**Re: Venice Volleyball Courts at 5801 Venice Ave NE  
Erosion and Sediment Control Plan  
Engineer's Stamp Date 2/5/24 (B18E022)**

James D. Hughes, P.E. CPESC.  
Principal Engineer, Planning Dept.  
Development and Review Services

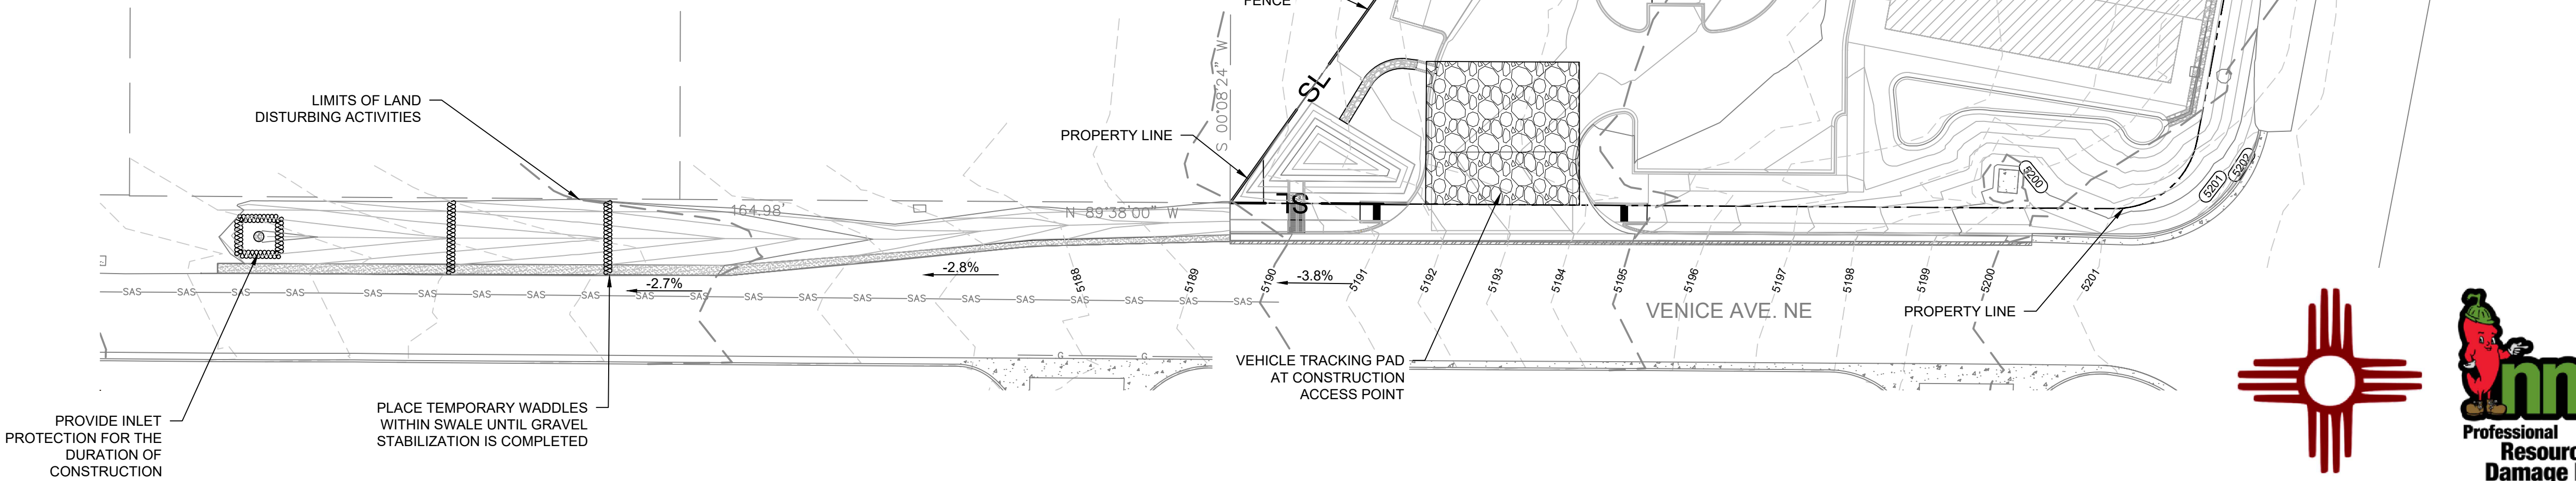
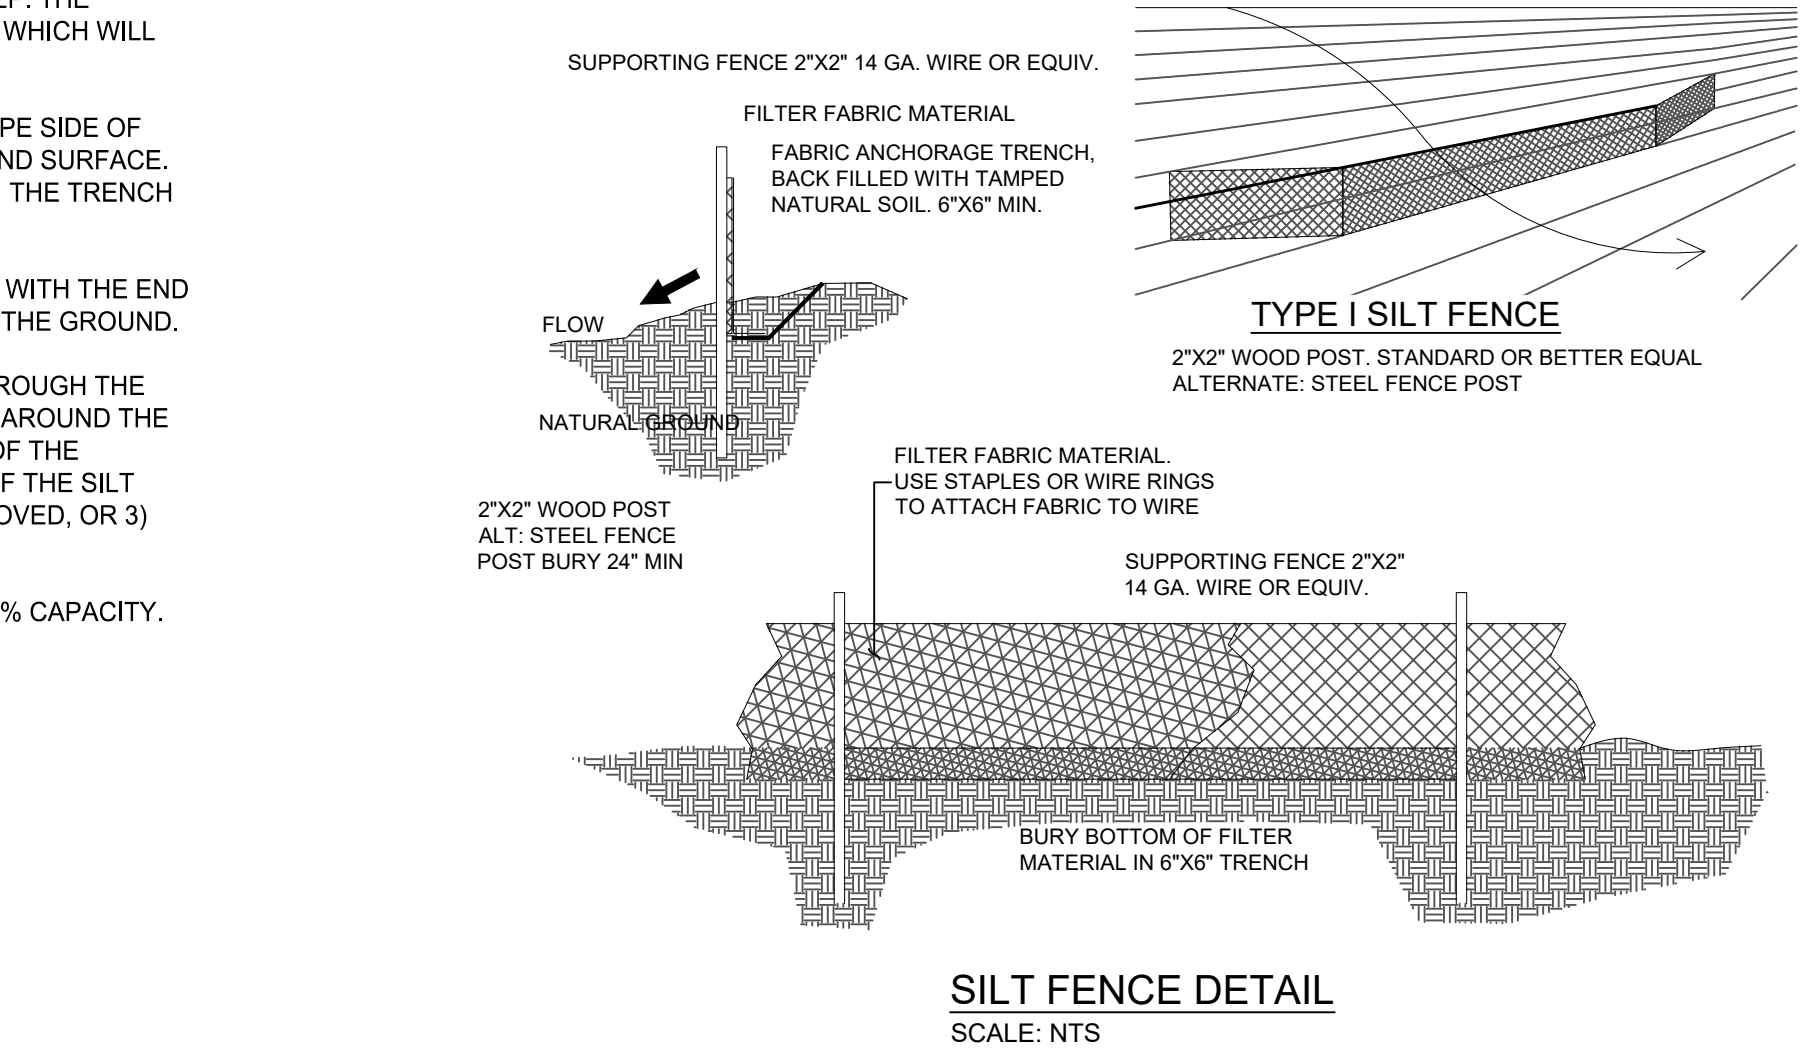
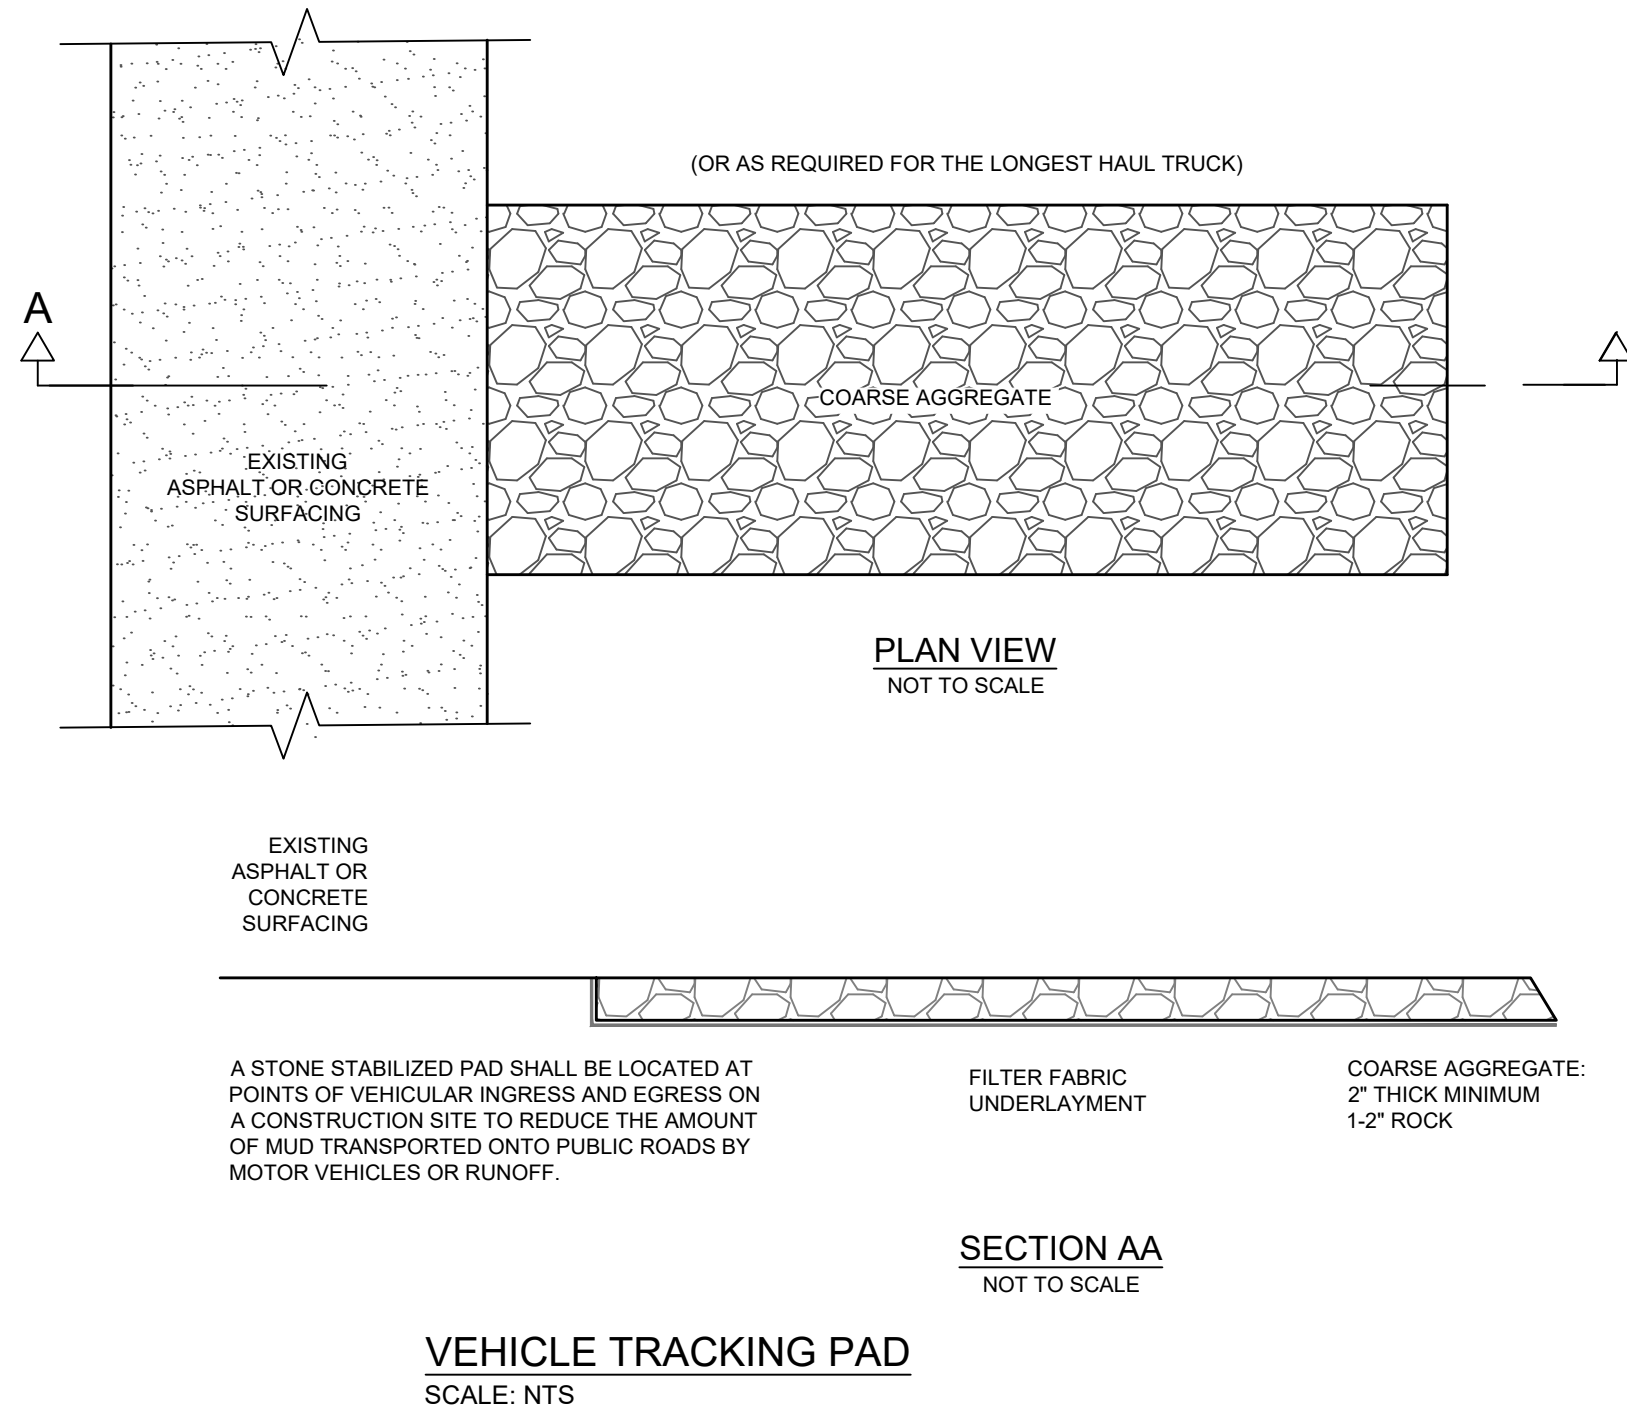
5. Mulch socks and/or fiber rolls are inappropriate controls for concentrated flows. Control stormwater discharges to minimize channel erosion and scour in the immediate vicinity of discharge points per CGP 2.2.11. Provide permanent velocity dissipation devices (e.g., rip-rap or rock check dams) within and along the length of the dirt channel next to Venice Ave. to slow down stormwater.

6. Note 8 in the Silt Fence Notes contradicts CGP 2.2.3.c.i and must be changed to agree.
7. The SWPPP must include site-specific interim and permanent stabilization specifications per CGP 9.6.1.c.i. The Landscape Plan can be used to satisfy this requirement and should be submitted separate from the ESC Plan with the application to the Stormwater Quality Section of the Planning Department and it should be included in the SWPPP. Provide a specification on the ESC Plan for any disturbed areas not covered by the Landscape Plan sheets.
